From: Sruli @ AJ Plans <sruli@ajplans.co.uk>
Sent: 20 June 2022 15:18
To: Emilie Bateman
Subject: RE: 60 HIGH STREET 4131/APP/2022/1654 DET
Attachments: Velux.pdf

From: Emilie Bateman <EBateman@hillingdon.gov.uk>
Sent: 17 June 2022 13:52
To: Sruli @ AJ Plans <sruli@ajplans.co.uk>
Subject: 60 HIGH STREET 4131/APP/2022/1654 DET

I am the case officer for application ref: 4131/APP/2022/1654 at 60 HIGH STREET.

Todi&Boys Joinery Standard Casement Construction

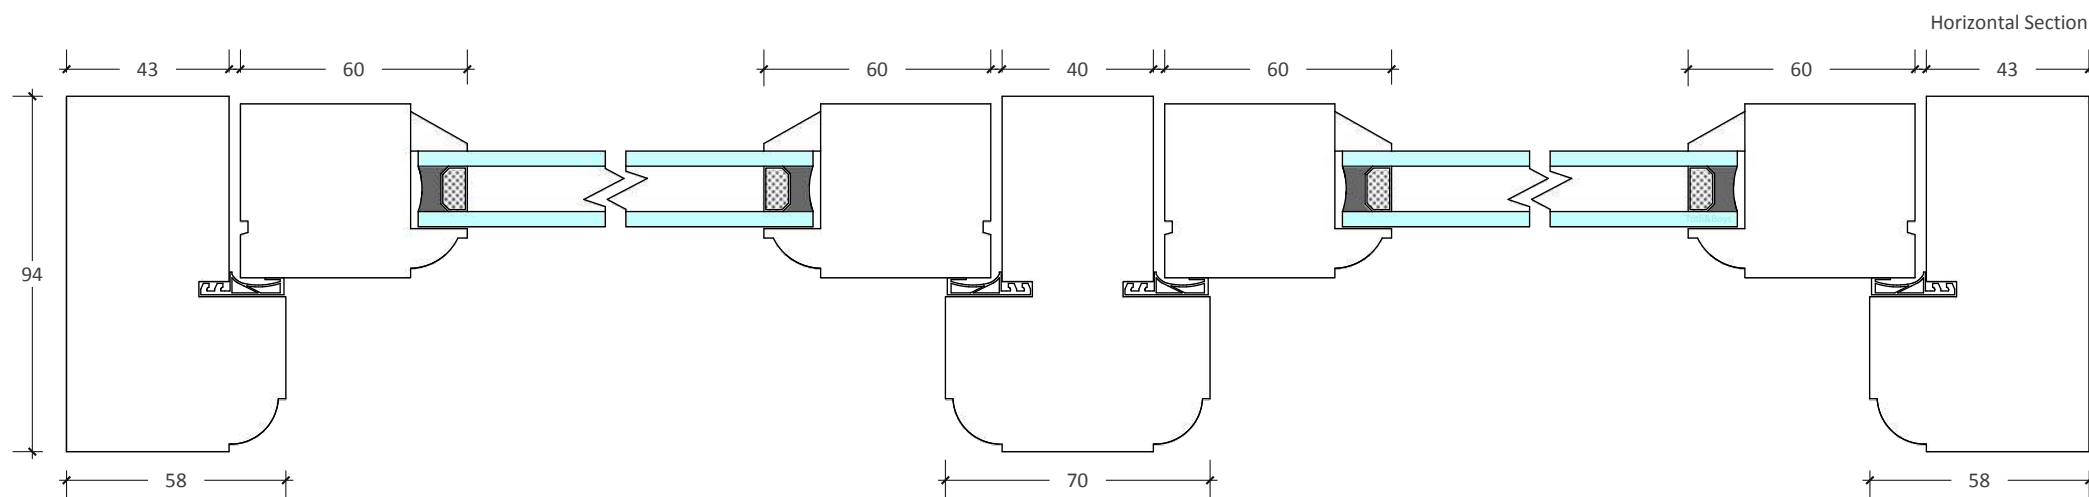
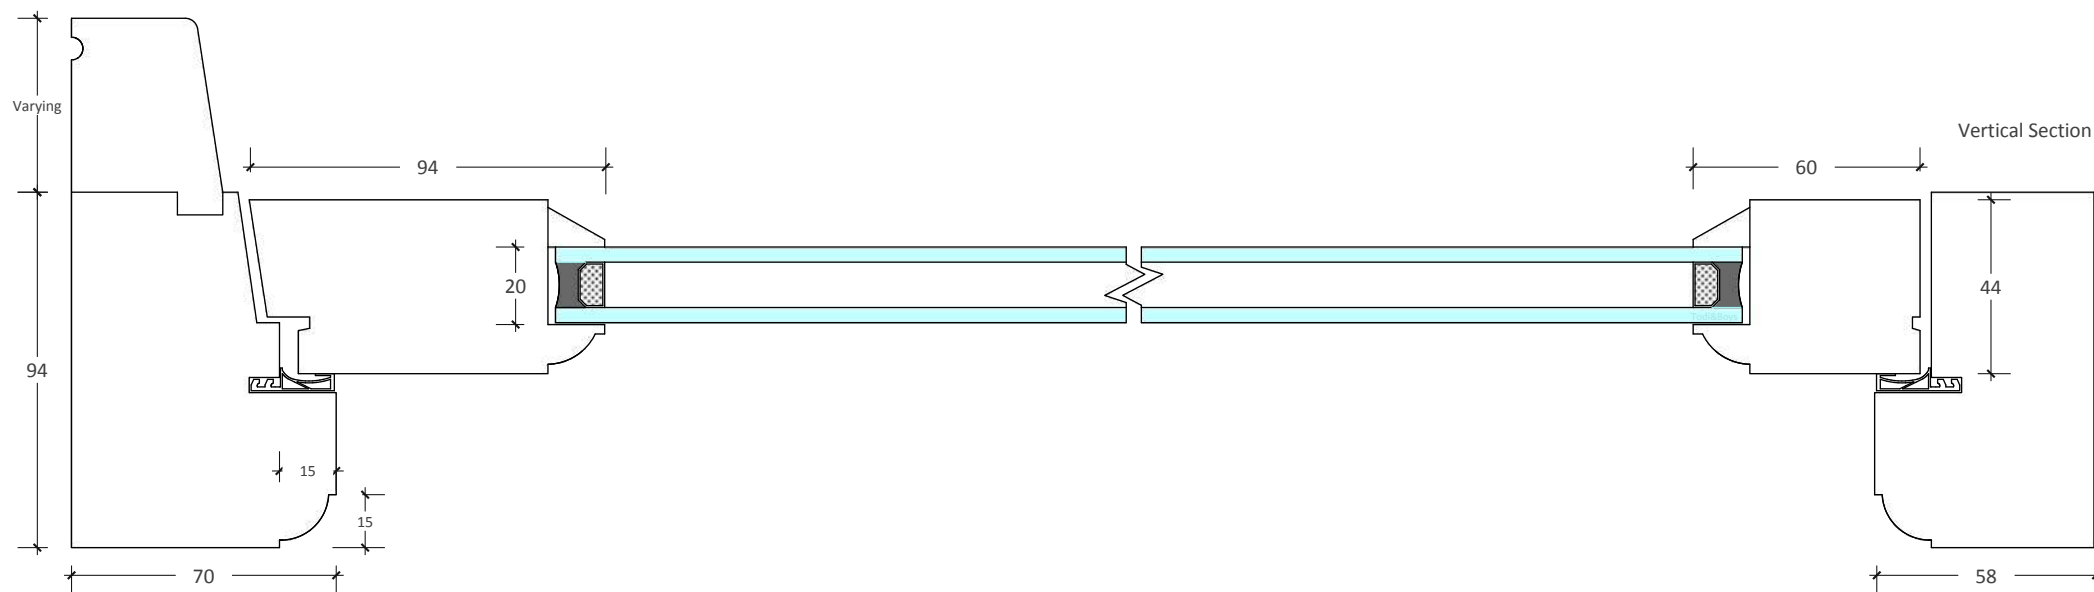
Regarding the windows, please confirm that the glazing will be leaded and what colour the frames are to be painted.

The glazing will be leaded and the frames will be black painted.
